DECISION DELEGATED TO HEAD OF PLANNING

Application No:	H01-0569-24	Applicant:	Mr T Hicks
Proposal:	Change of use of steel portal framed building to residential dwelling		
Location:	104 Barrier Bank Cowbit Spalding		
Terminal Date:	3rd September 2024

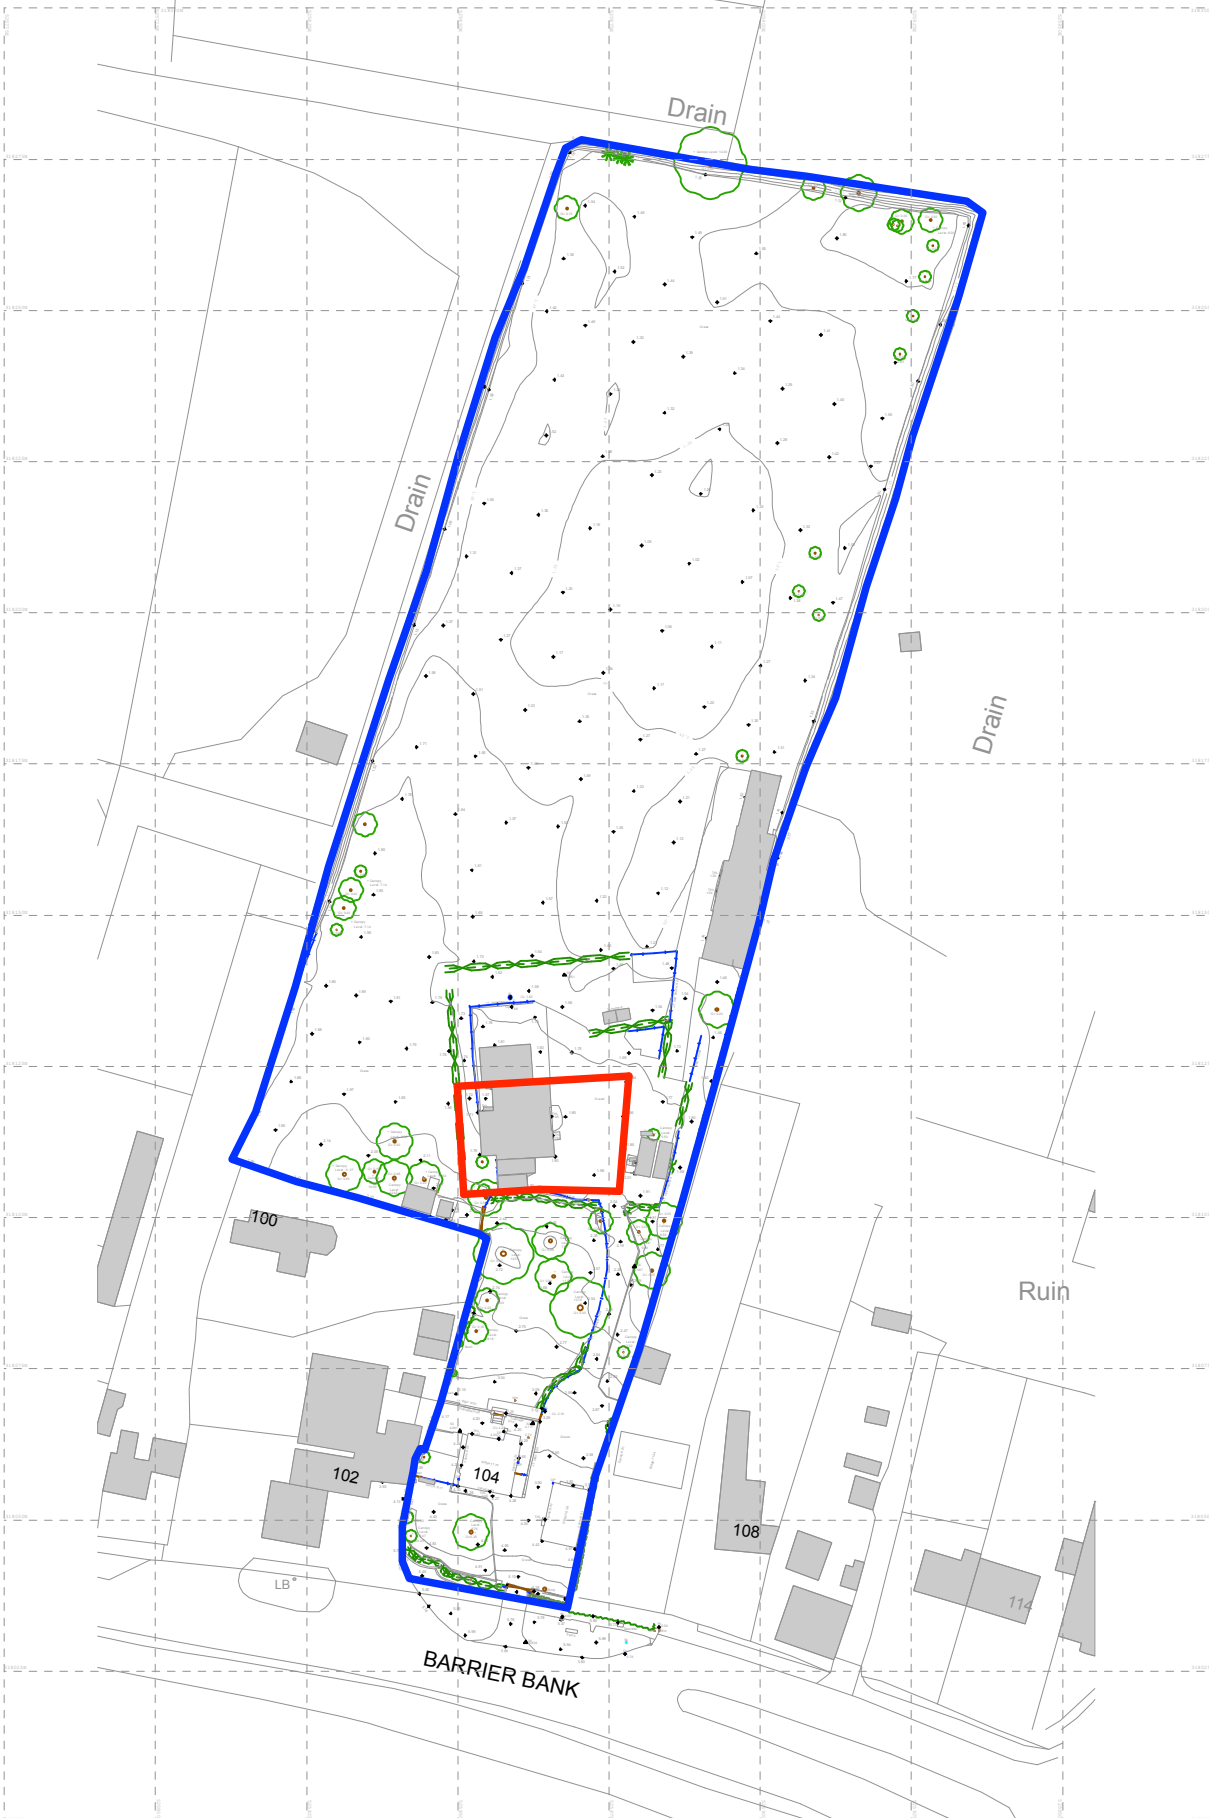
A shared access needs to measure a minimum of 4.1m wide - the width needs to be demonstrated in accordance with this.

Following a measurement of the plan the access is currently 3.5m wide. This has not been raised with the applicant given that the Local Planning Authority considers that there is fundamental issues with the proposal.
